DECISION DELEGATED TO DEVELOPMENT MANAGER

Application No: H16-0856-19 **Applicant:** Alexandra Brown
Proposal: Proposed pair of semi-detached house
Location: Site Rear: 175 Hawthorn Bank Spalding Lincs
Terminal Date: 24th October 2019

PROPOSED ELEVATIONS

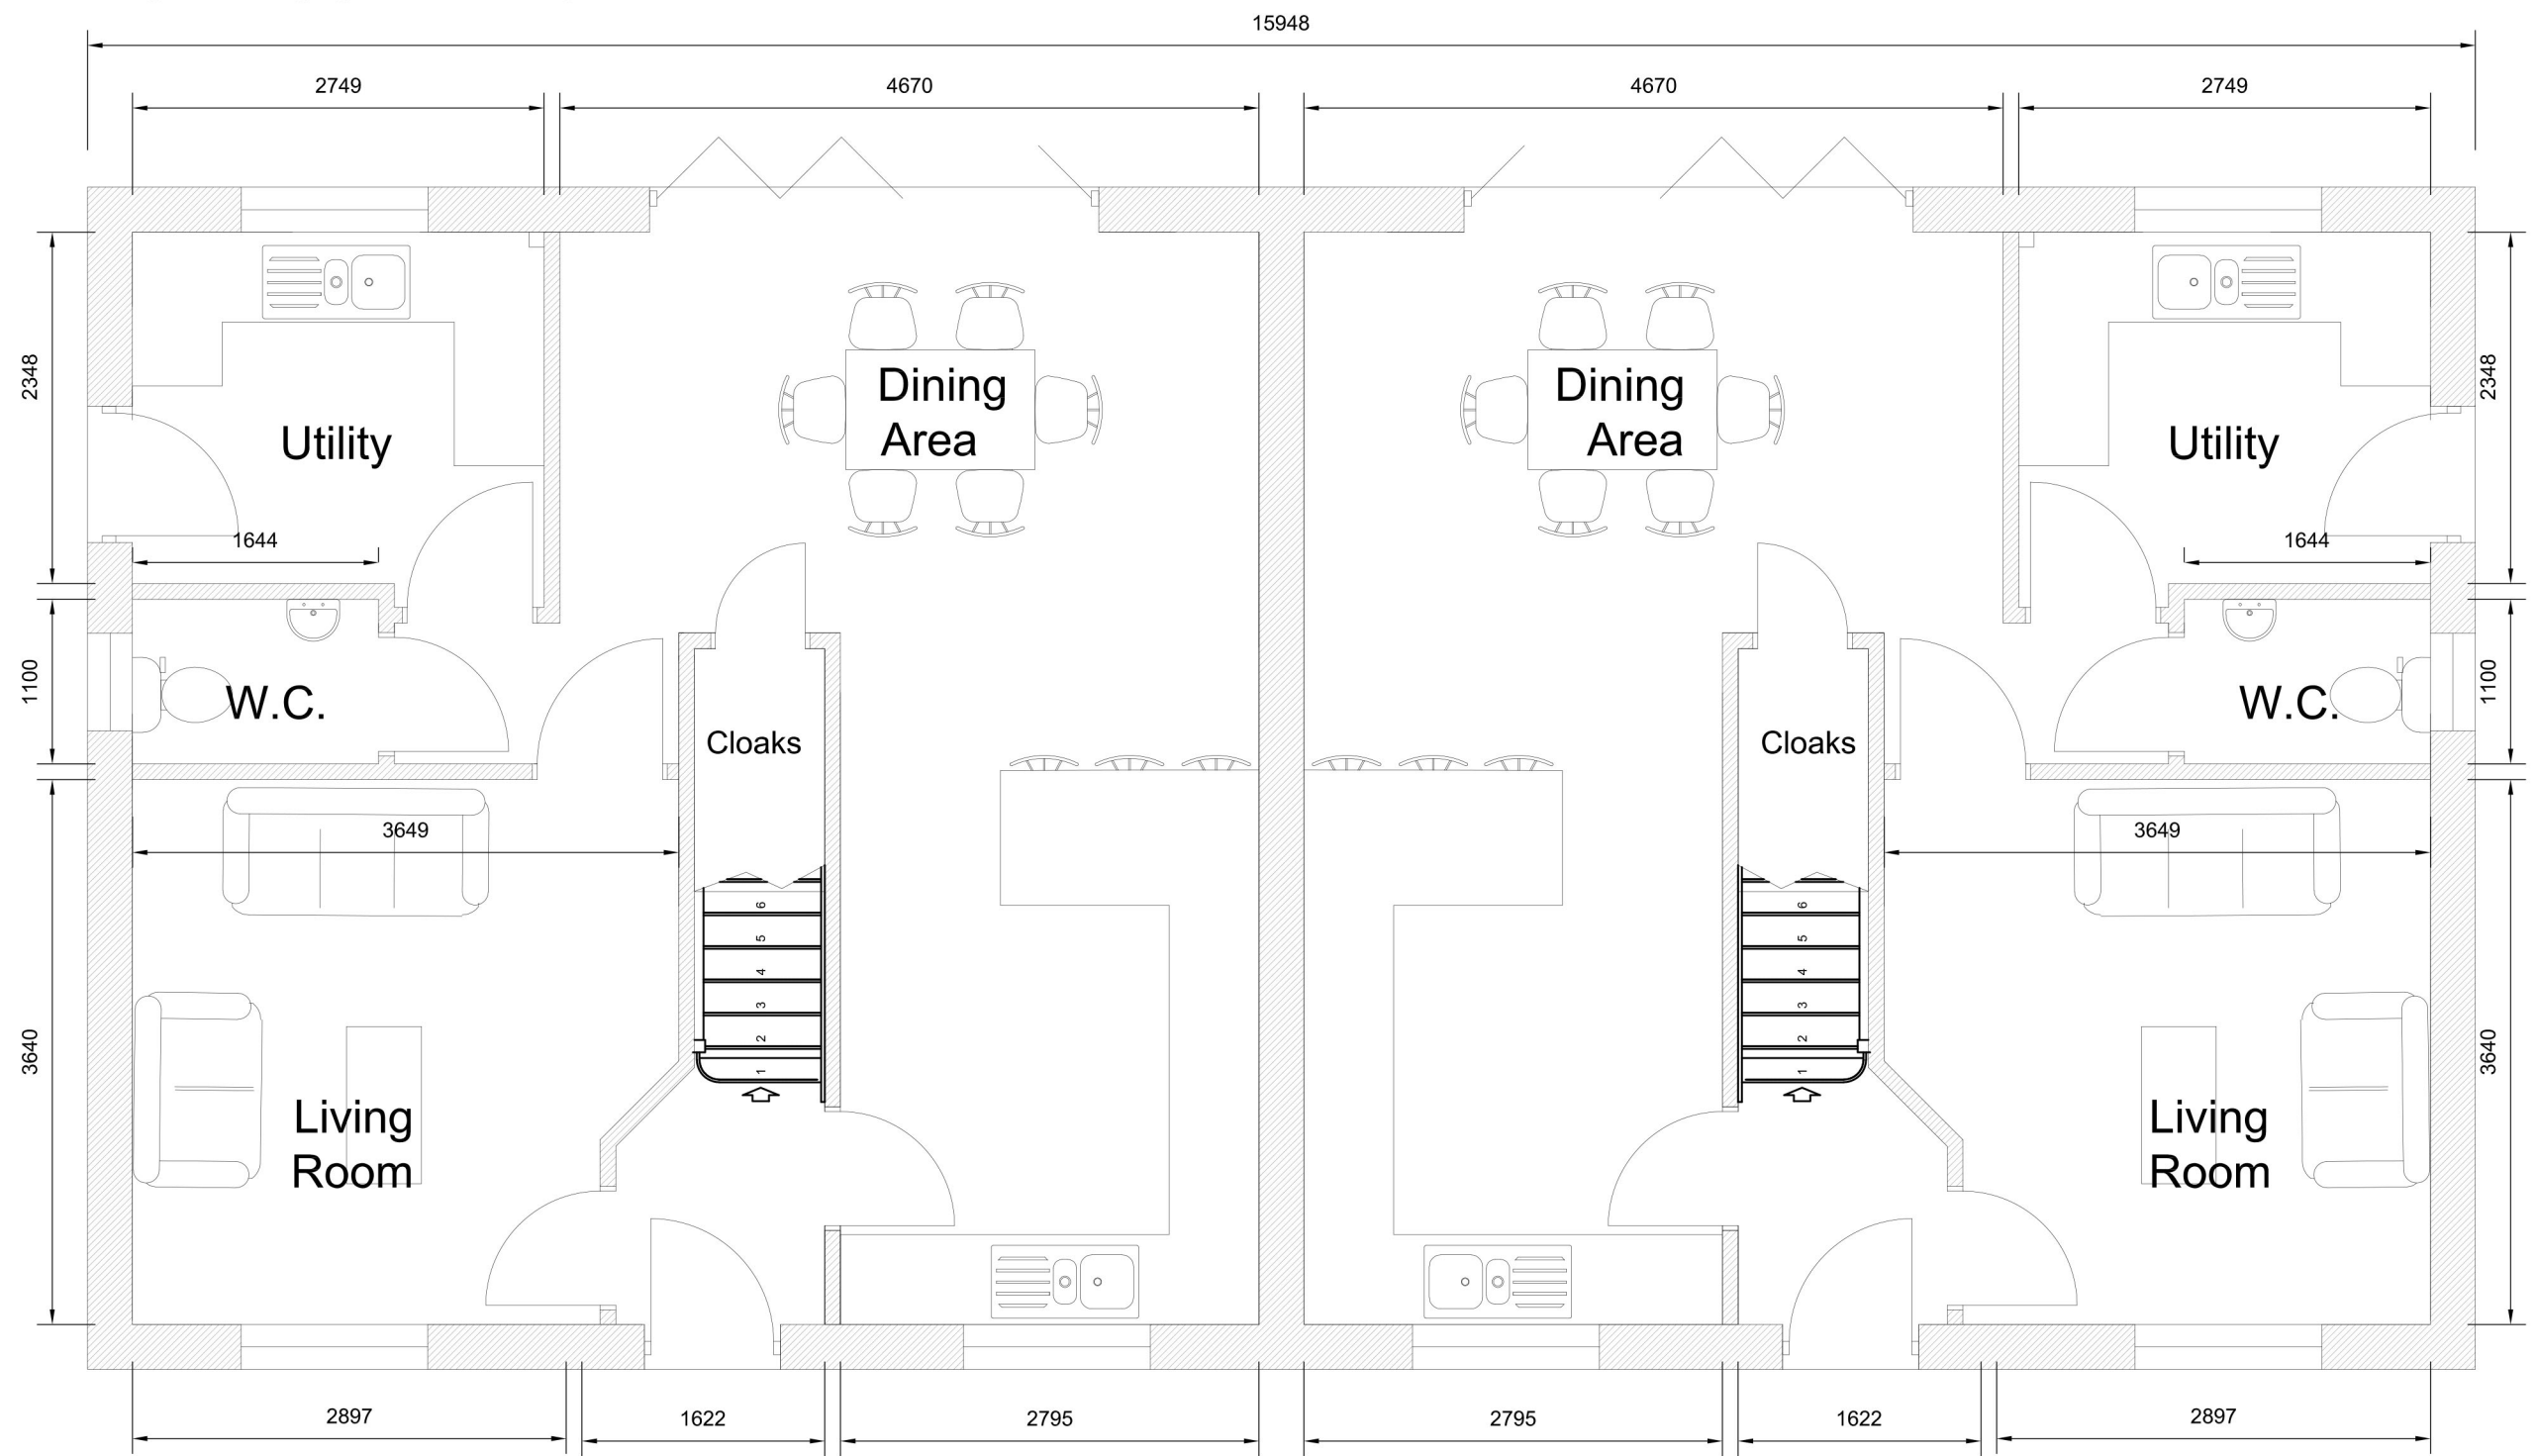
The submitted indicative proposal has been designed in such a way as to minimise overlooking and overshadowing concerns. However, taking into account the necessity to raise finished floor levels to 300mm above ground level and the plot being higher topographically than that of surrounding properties, it is considered that the development will have an overlooking impact.

The proposed plots provide an acceptable level of amenity for occupants, however the design is out of keeping with surrounding properties and not considered to be of substantive architectural quality.

PROPOSED BLOCK PLAN

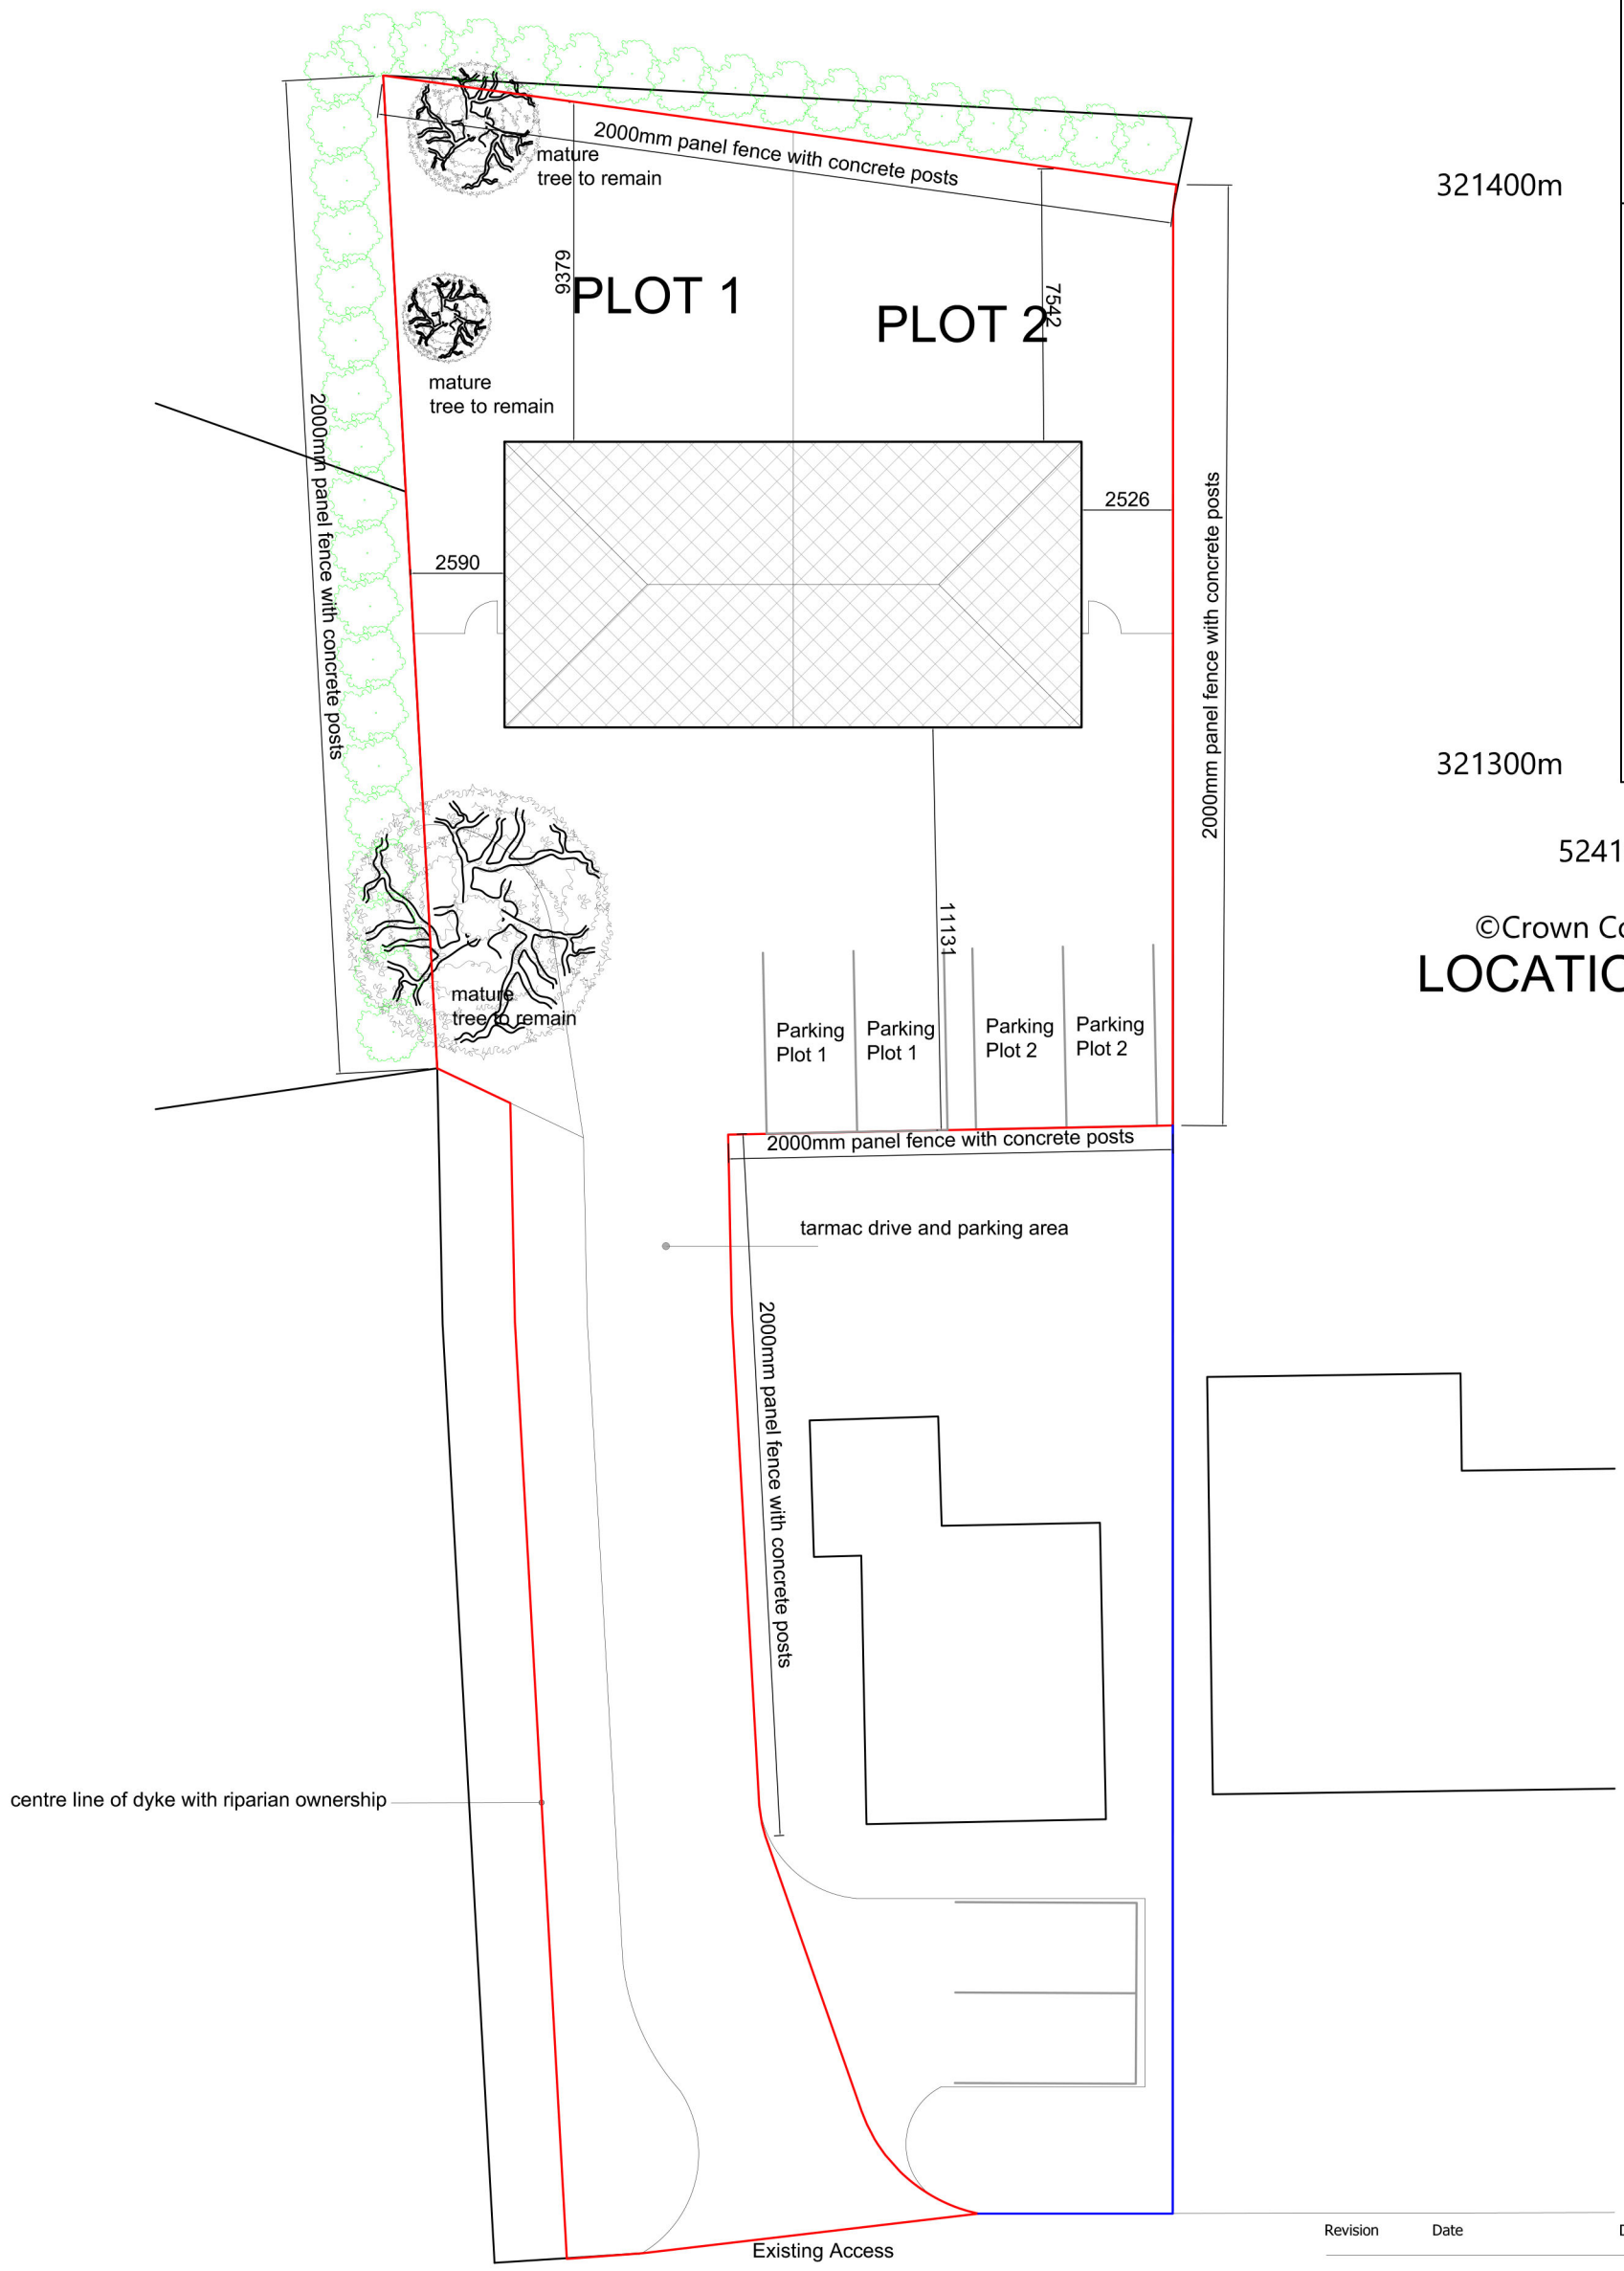
The County Highways & SUDS Officer has not expressed any manoeuvrability concerns. It is officer opinion that the parking location does not allow for easy manoeuvring, especially for larger family vehicles.

The proposed development would constitute a cramped and incongruous form of development that would be at odds with the character of the surrounding area by virtue of the size of the plot, its location and relationship with neighbouring properties. As such, the proposal is considered contrary to Policies 2 and 3 of the South East Lincolnshire Local Plan, 2019. These policies indicate that new development will be permitted on suitable sites in Area Centres and should make a positive contribution to the character and appearance of the locality.

No cycle storage areas have been provided and garages do not form part of the design, so any bicycles would like have to be stored within the properties.
